# CITY OF ALBUQUERQUE

**RE: Premier M.H Display Yard  
Request for Certificate of Occupancy  
Hydrology Final Inspection - Disapproved  
Grading Plan Stamp Date 7/12/17 (M14D012C2)  
Certification Dated: 9/14/18**

2700 BROADWAY BLVD, SE
A PREMIER DEVELOPMENT
Site - Grading & Drainage Plan

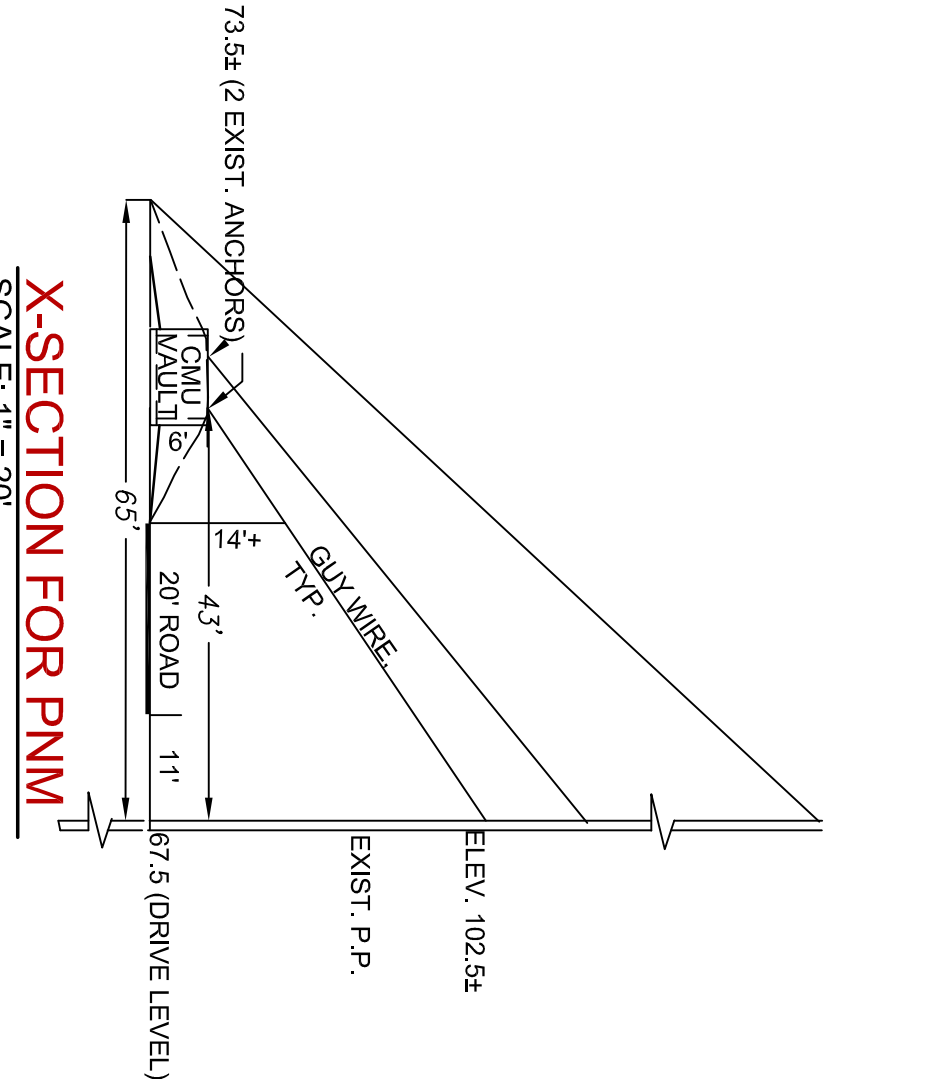
2. The CMU wall needs to be constructed to elevation 4963.0' (minimum) per the approved grading plan and resurveyed once complete.
3. The basin B pond needs to be modified to provide retention of 100cf (minimum) per the approved grading plan; it cannot free drain.
